KITTITAS COUNTY FIRE MARSHAL'S OFFICE

July 20, 2014

Re: Biddle (BL-14-00002)

After conducting a review of the recent changes to the above named project, I have the following comments:

BIDDLE SHORT PLAT		
PREPARED FOR RAY BIDDLE		
A PTN. OF THE SE 1/4 OF SEC. 5 & A PTN. OF THE NE 1/4 OF SEC. 8 TOWNSHIP 19 N., RANGE 16 E., W.M.		
KITITITAS COUNTY	DATE	JOB NO.
DWN BY G. WEISER	07/2014	14052
CHKD BY D. NELSON	SCALE 1"=100'	SHEET 1 OF 2

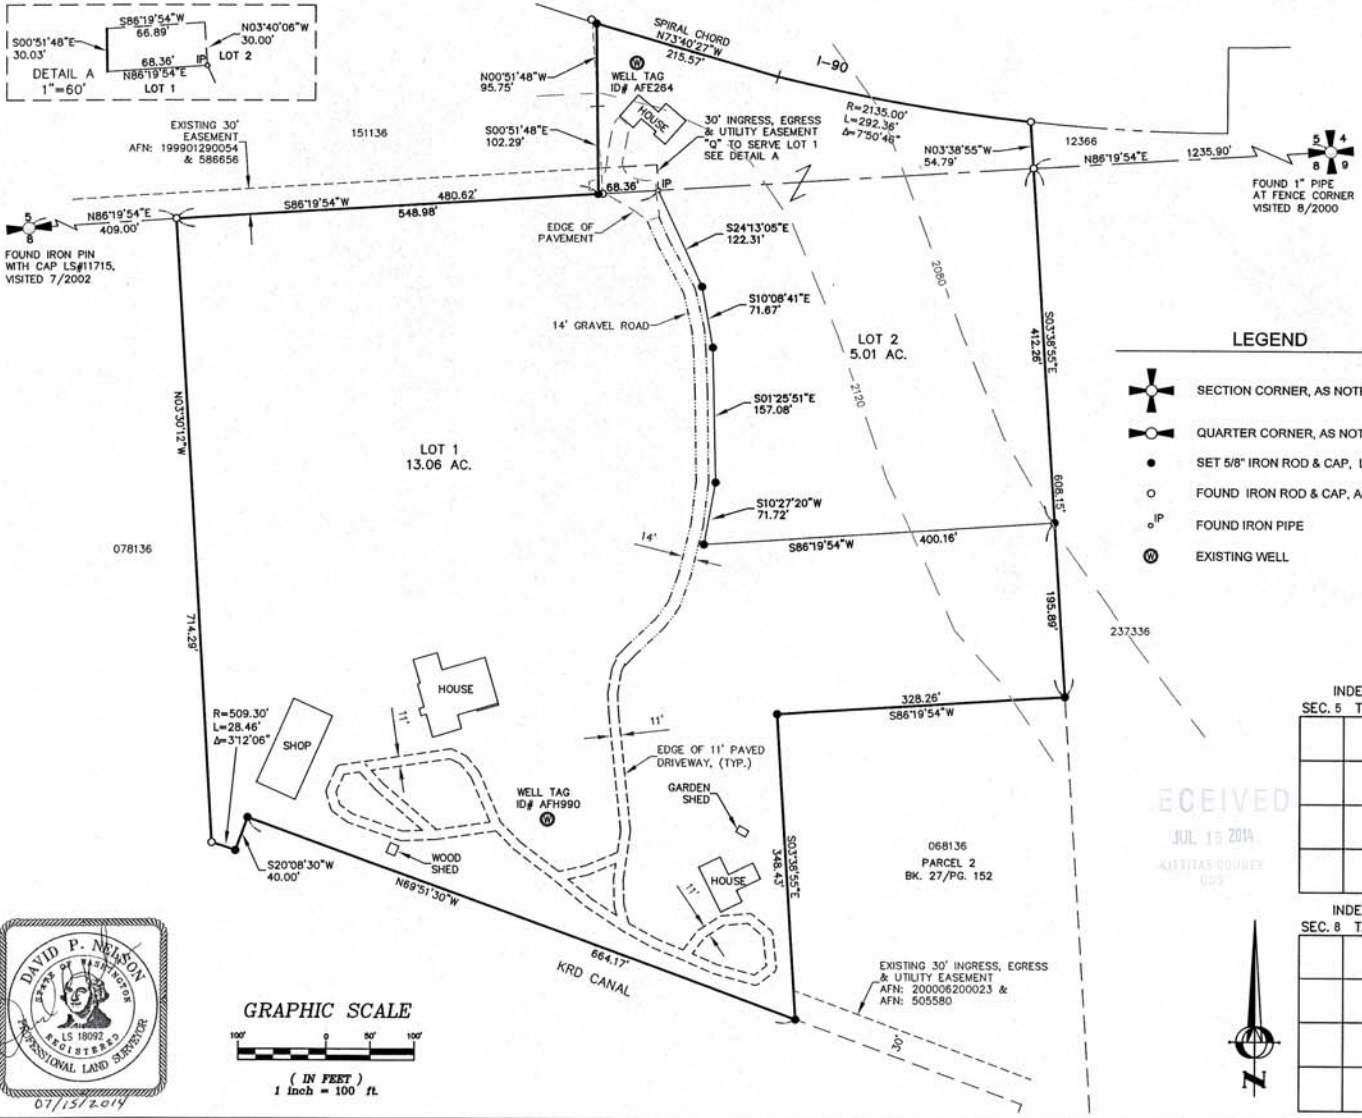
- Ensure that boundary line adjustments do not infringe upon existing structures, to include propane tanks, etc.
- Ensure adequate access for fire apparatus. Any driveways or access points created based off the new lot configurations shall comply with Kittitas County Code 20.02.030.
- All future development must comply with the International Fire Code.
